DOC18/384563-02
SSD 9249

**SSD 9249 – SYDNEY FOOTBALL STADIUM RE-DEVELOPMENT
(CONCEPT PLAN AND STAGE 1) – ENVIRONMENTAL IMPACT STATEMENT (EIS)**

Attachment A

Figure 2-2 Construction Site Plan

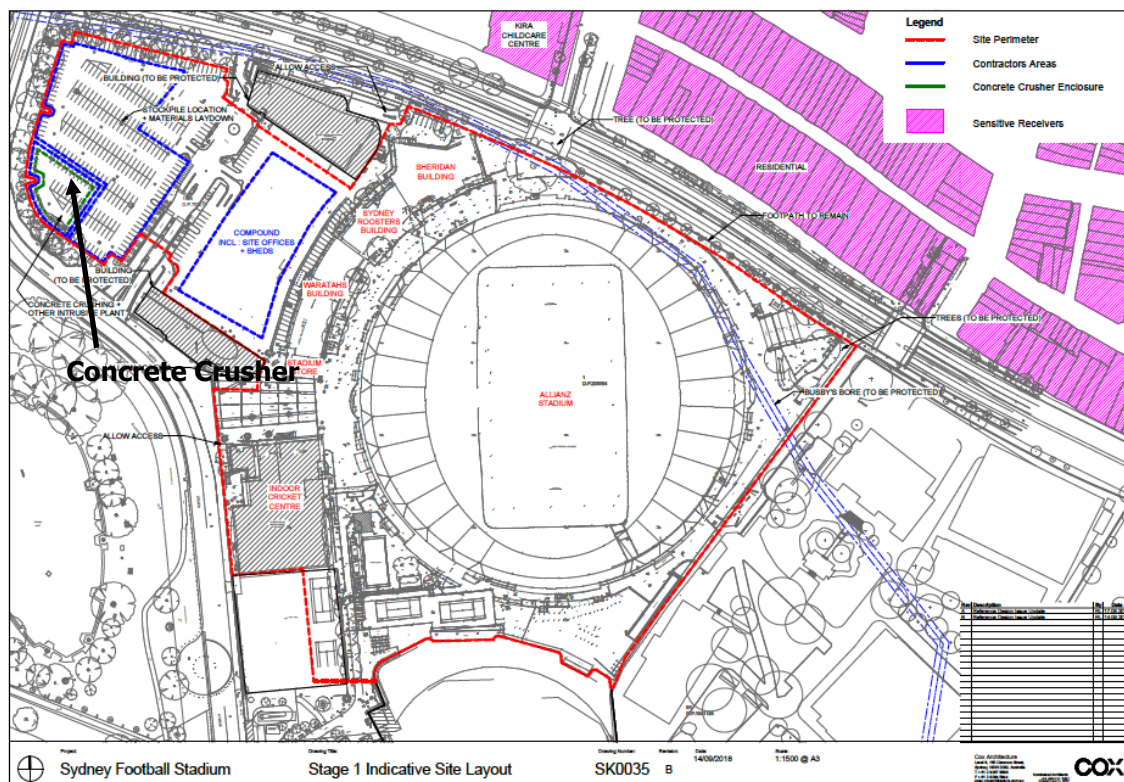
The EIS (Figure 21 (p.43)) indicates that the ‘Stage 1 Demolition Site Compound’ is to be located between the NRL and ARDC buildings which adjoin the compound to the south and north respectively. The EPA understands that both the NRL and ARDC buildings would continue to operate throughout

- does not identify the adjoining ARDC building as an 'educational institution' in Figure 3 (*Noise sensitive receiver locations and NCAs*),
- recommends in section 6.1.3 that the noisy concrete crusher be located "... to the south of the site as far from receivers as possible." which would be near the ARDC building,
- incorrectly identifies the University of Technology Sydney as a 'Commercial' usage in Table 3 instead of an 'educational institution',
- incorrectly assesses impacts against the management level for commercial premises rather than classrooms at an educational institution, and
- incorrectly suggests in section 7.1 the possibility that the NRL and ARDC buildings may not "... remain operational during demolition works."

- (a) identify the adjoining University of Technology Sydney occupancy of the ARDC building as an 'educational institution' as referred to in Table 3 to the Interim Construction Noise Guideline,
- (b) re-assess the predicted noise impacts of demolition activities and the concurrent concrete crushing and related loading/stockpiling operation against the applicable 'management level' (i.e. internal noise level) for an educational institution,
- (c) identify when University of Technology Sydney classrooms would be in use, and
- (d) propose feasible and reasonable noise mitigation measures to ensure the applicable 'management level' (i.e. internal noise level) is not exceeded.
